#3 Suggested Condition of Approval Included in Planning Board Report Re: 415 Cumberland
emailed to Applicant 4/23/18.

Planning Board Public Hearing 04.28.2018

415 Cumberland Avenue, Building Renovation: Commercial & Residential

3 | PENTHOUSE FLOOR PLAN  
1/8" = 1'-0"

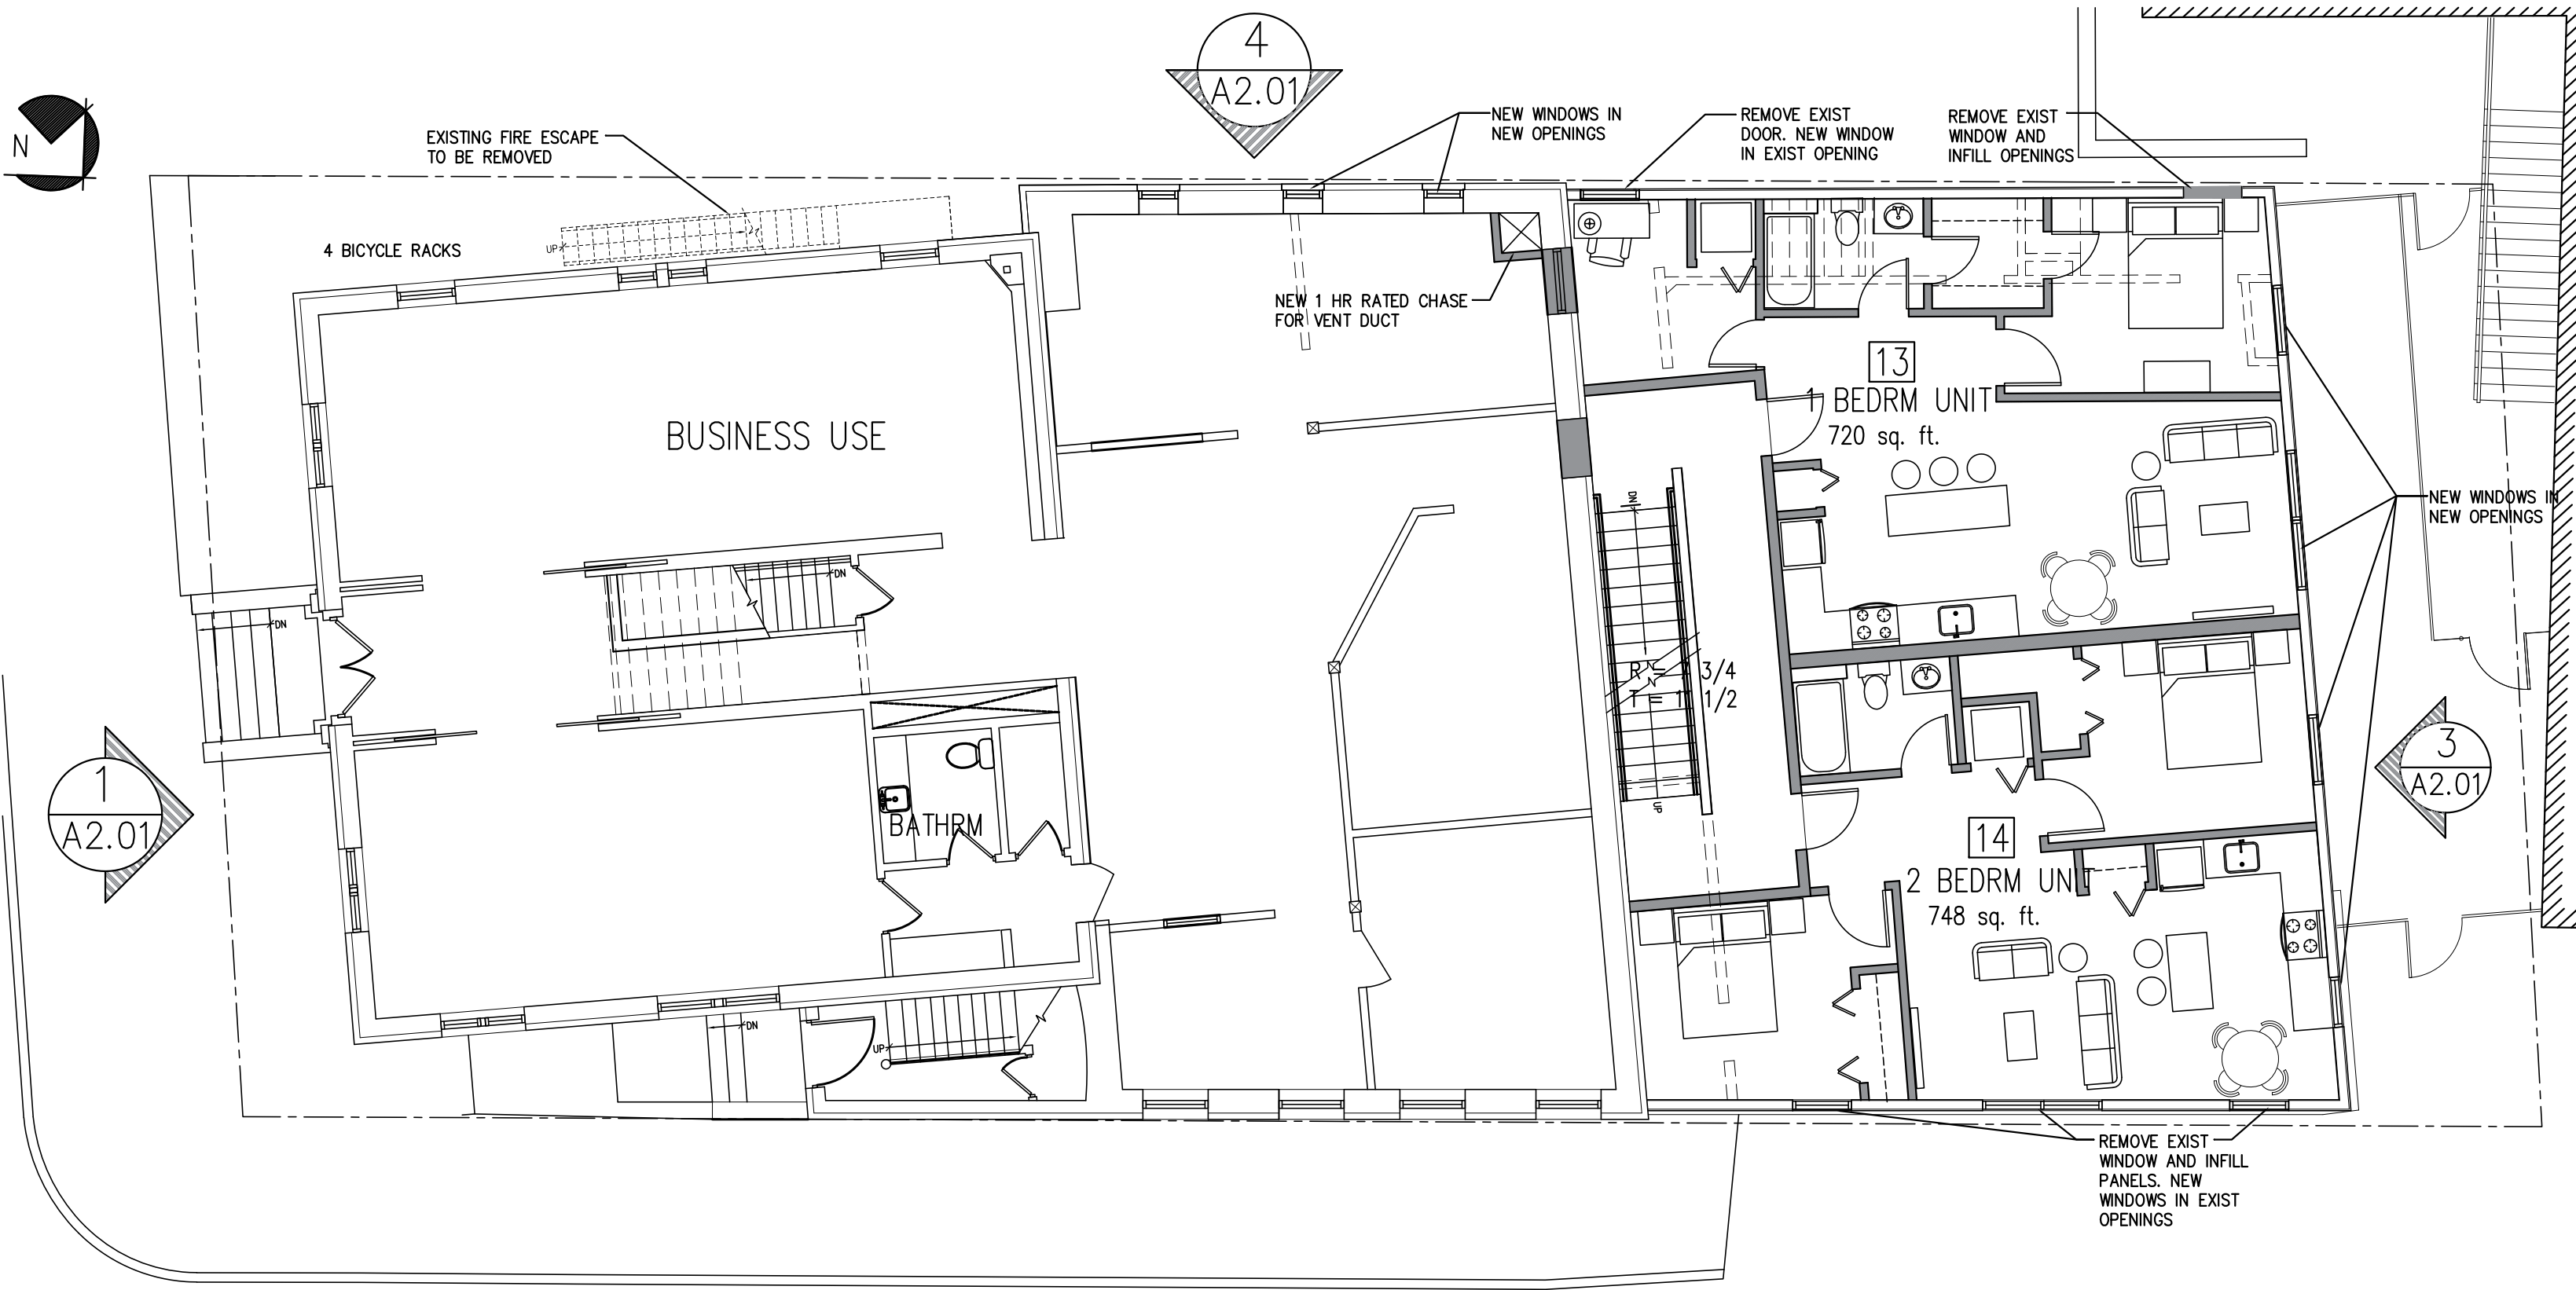
14. Please provide more clarity / detail regarding the penthouse / mezzanine. What changes are being made, if any, and what materials are being used? Are the proportions of the existing windows changing?
